# Letter of Intent\_V2.pdf Markup Summary

LETTER OF INTENT

PCD File #: AL-22-010

RE: Briana Carrasco & Erika Carrasco

INTEGRITY I.L.C. Services
Improvement Location Certificate
(This is not a property survey)

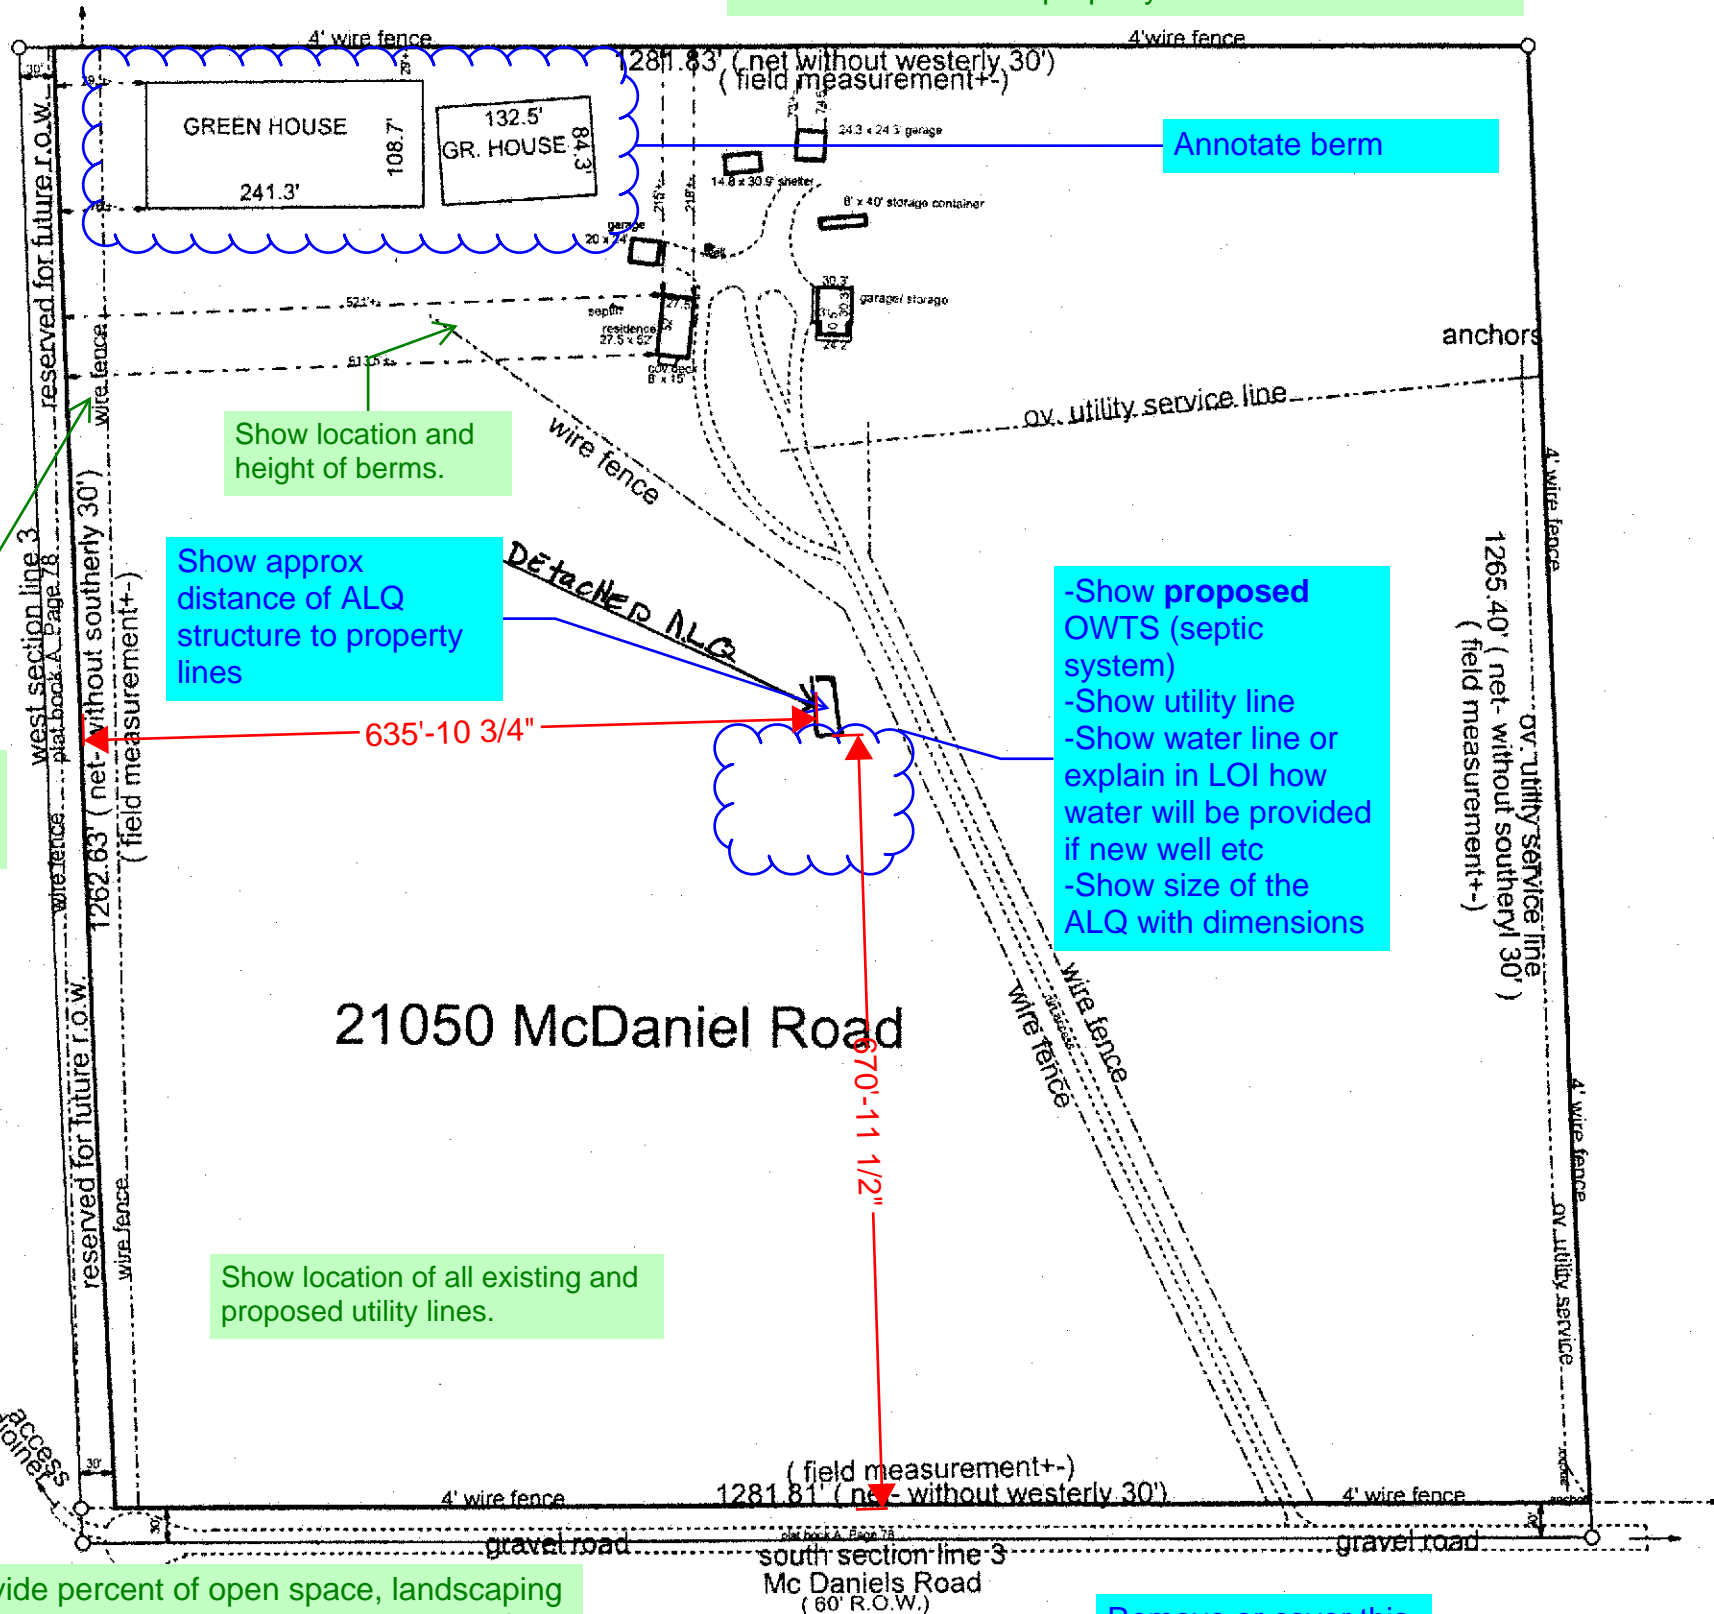
Please elaborate on the discussion and analysis of how the proposed special use is consistent with the 5.3.2 Special Use in the Land Development Code.
